**Springvale Mine Extension Project
Environmental Impact Statement**

NSW Trade & Investment, Regional Infrastructure & Services, Division of Resources & Energy (DRE) has reviewed the *Springvale Mine Extension Project Environmental Impact Statement (EIS) dated April 2014* and provides the following comments which are directed at specific areas of DRE's responsibility for this proposal.

FIGURE 3

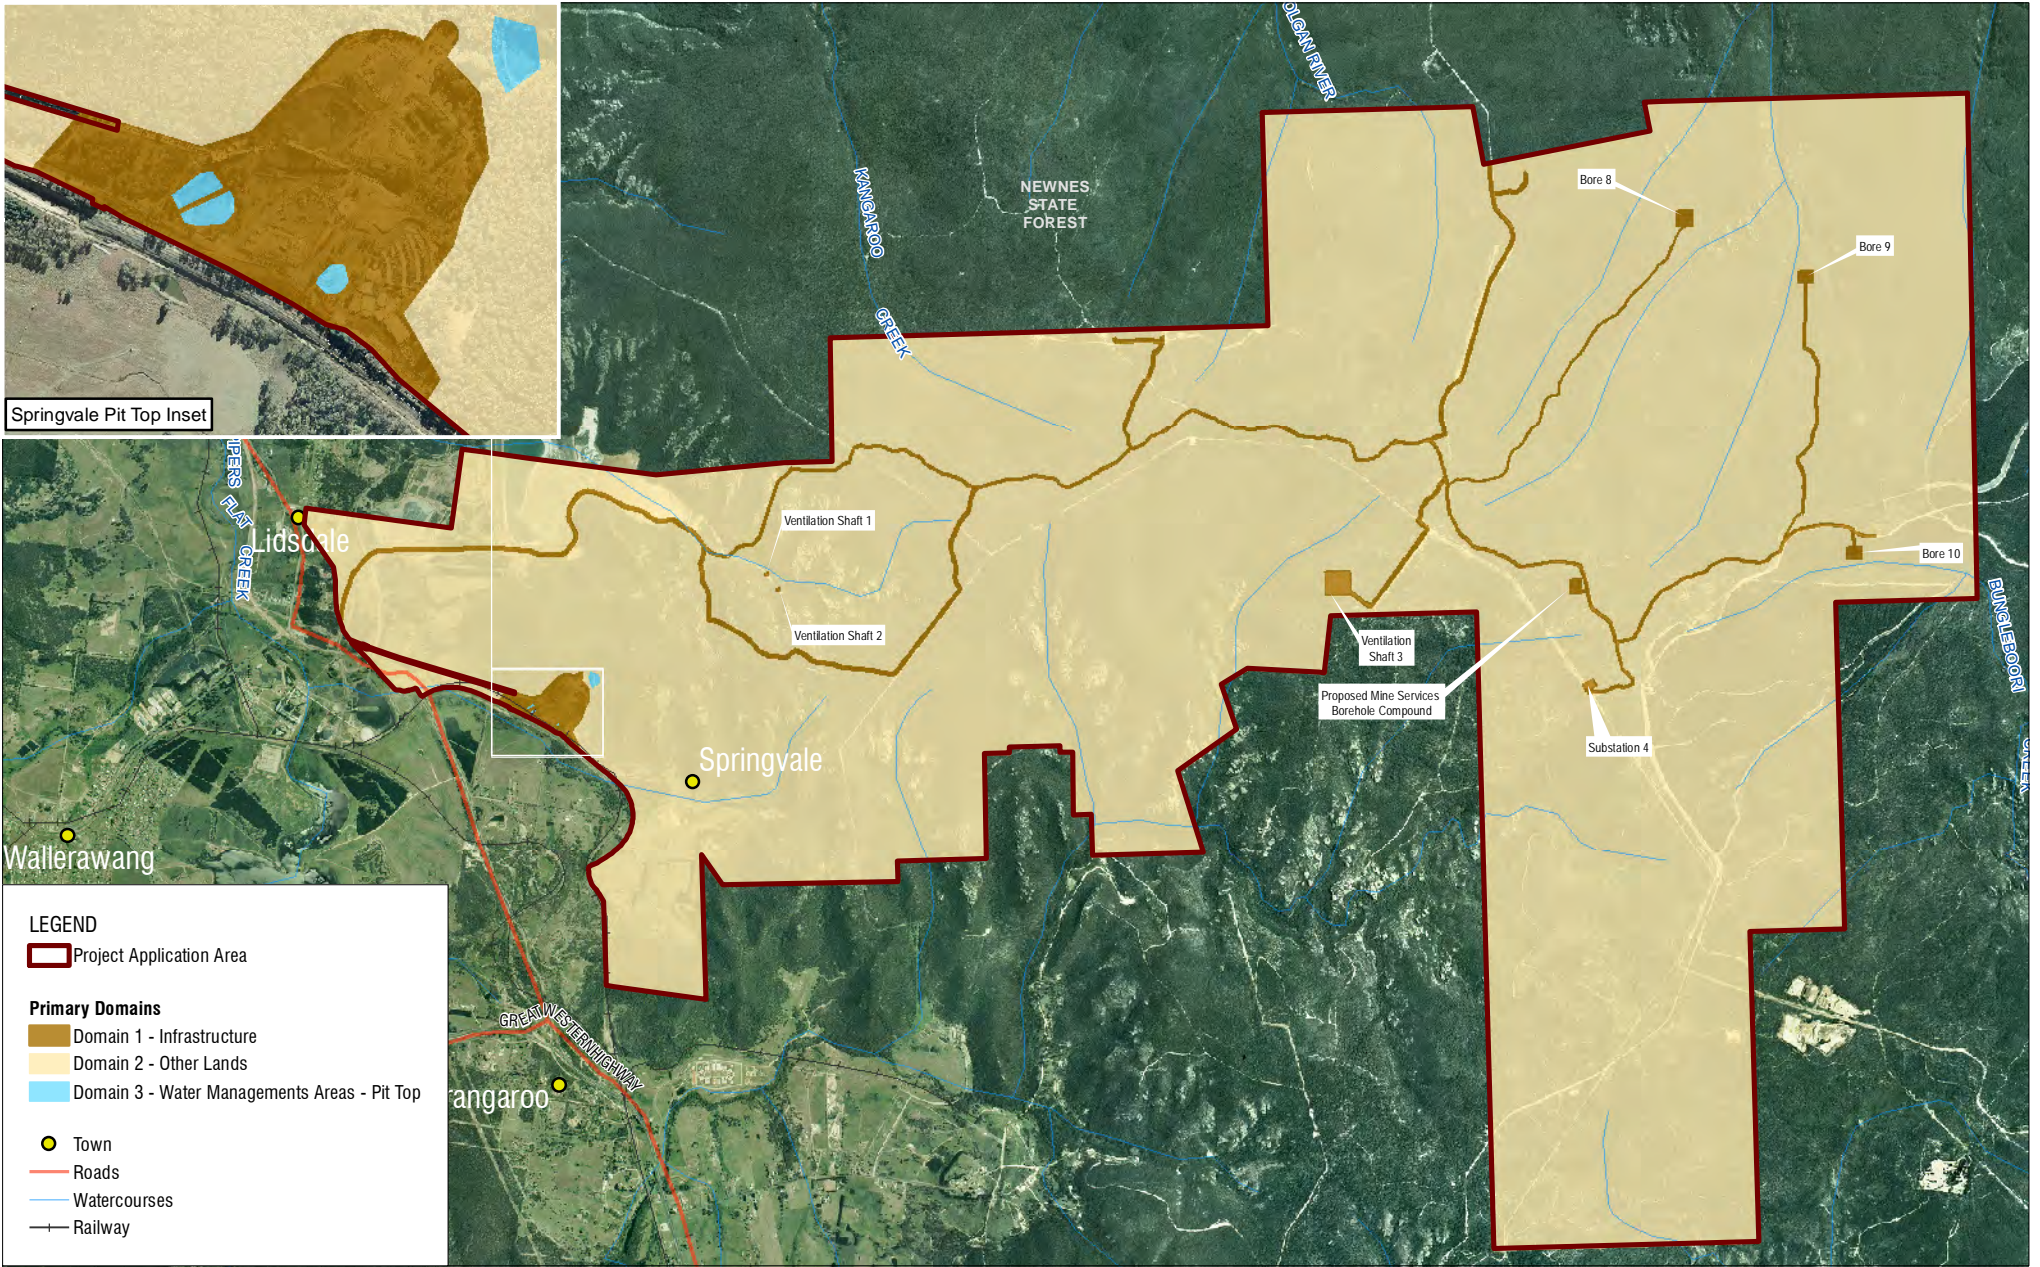
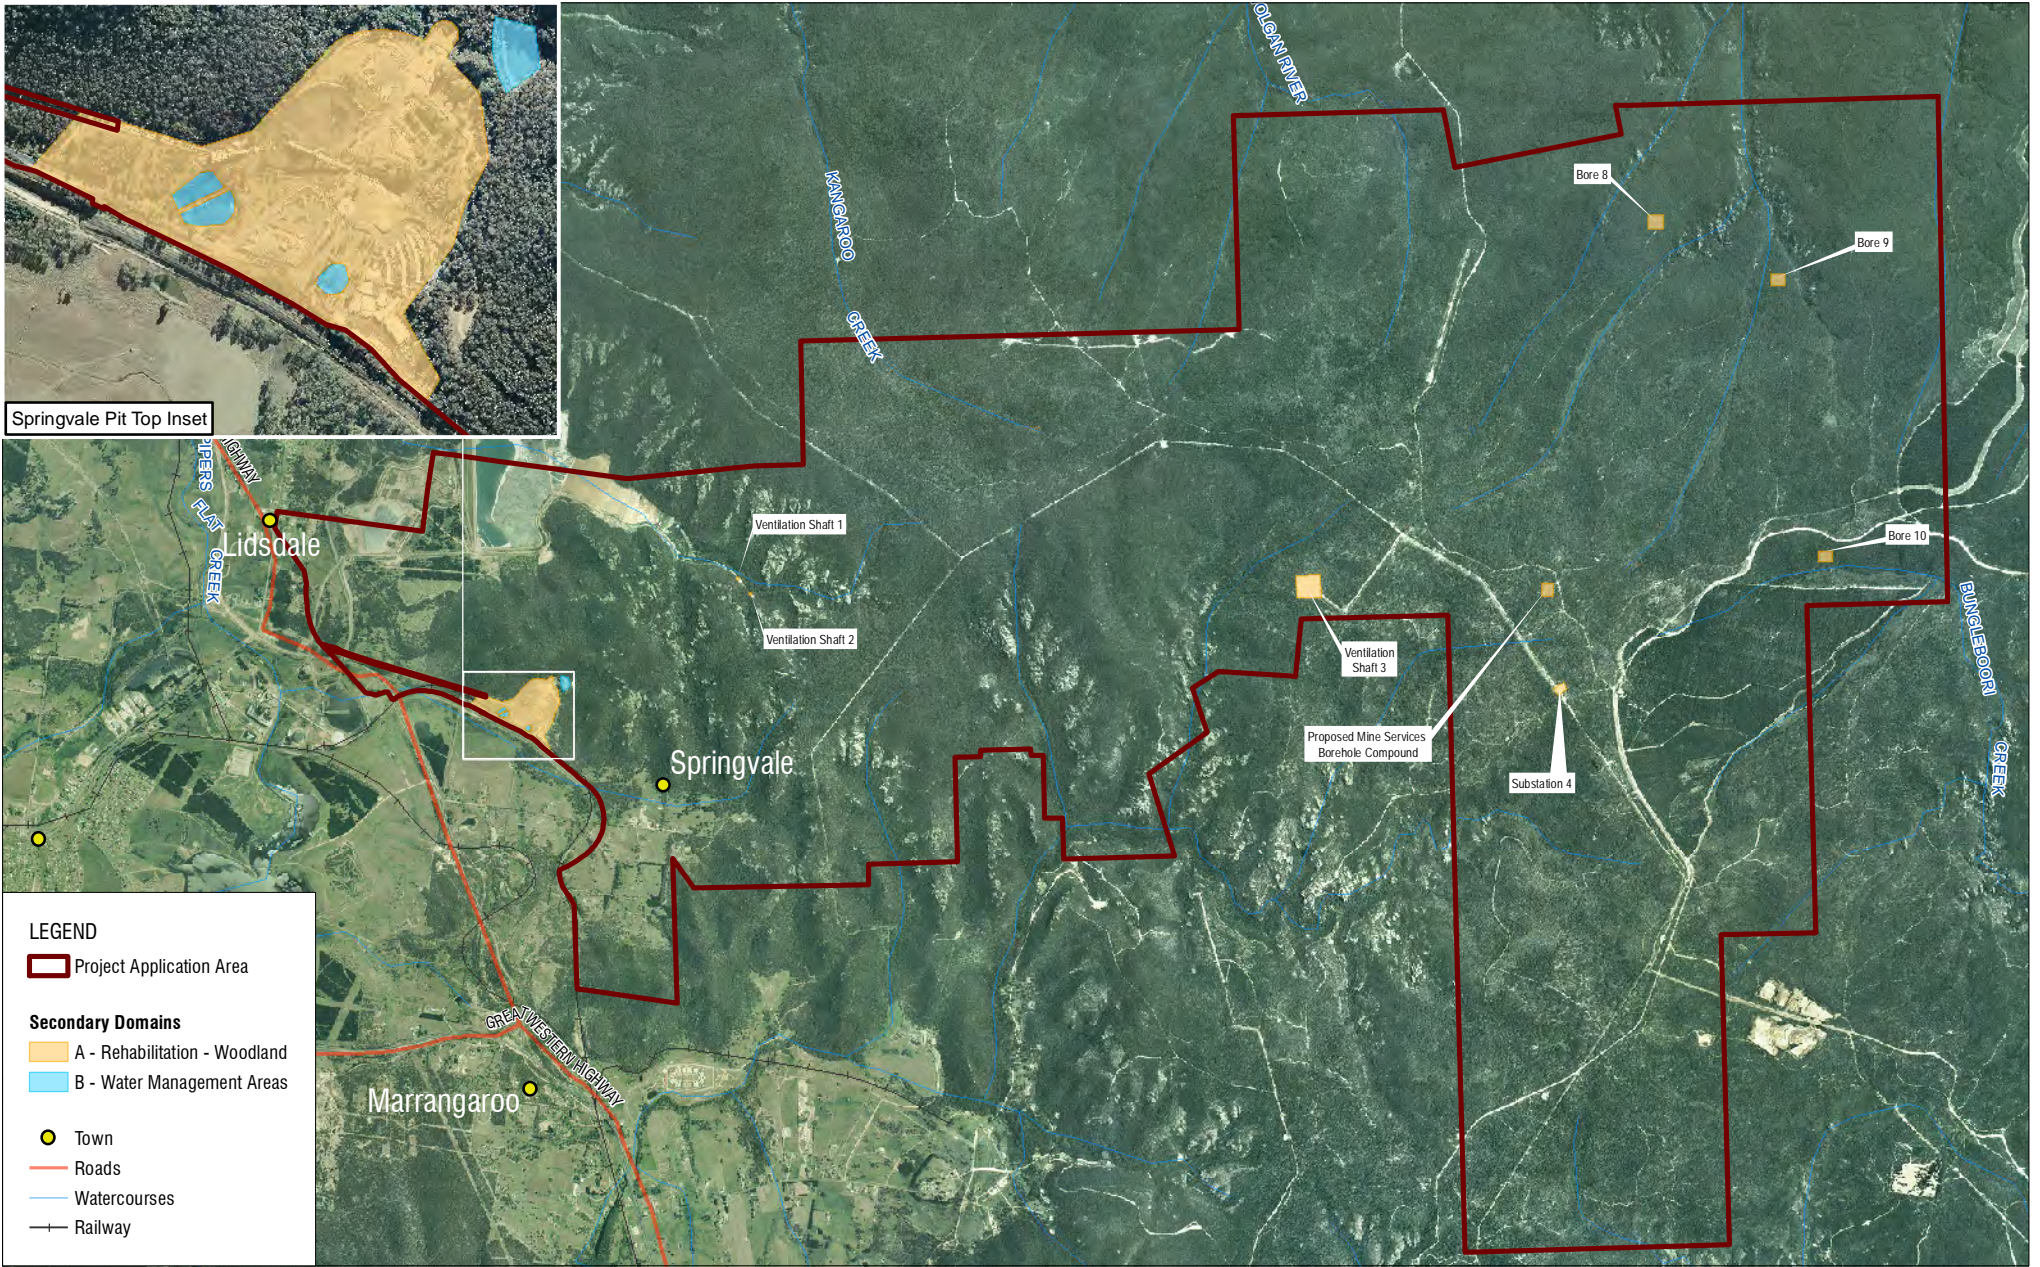
It is noted that all rehabilitation areas will now be either Woodland or Water Management Area. The draft EIS had an additional category for Grassland. It is unclear why the grassland rehabilitation outcome has been removed as it would appear to have been an appropriate final land cover for sections of the pit top site.

- statements regarding depth of cover (in Section 8.2 cover is referenced at between 300m and 430m, while other sections clearly show and state depth of cover between 180 and 420m),
- conflicting numbering reference for the Burrallow Formation (AQ5 or AQ6?)
- the area of land clearing (11.44ha or 11.8ha – both stated on page 441).
- It is noted that the final sentence on Page 456 states the final landform will comprise the domains of Woodland, Grassland and a Water Management Area. However, in the previous section 'Rehabilitation Outcomes', Grassland has now been removed from the post mining rehabilitation outcomes.
- Domain 2 in Table 10.49 indicates Domain 2 as a Water Management Area, while previously this has been referred to as Domain 3.
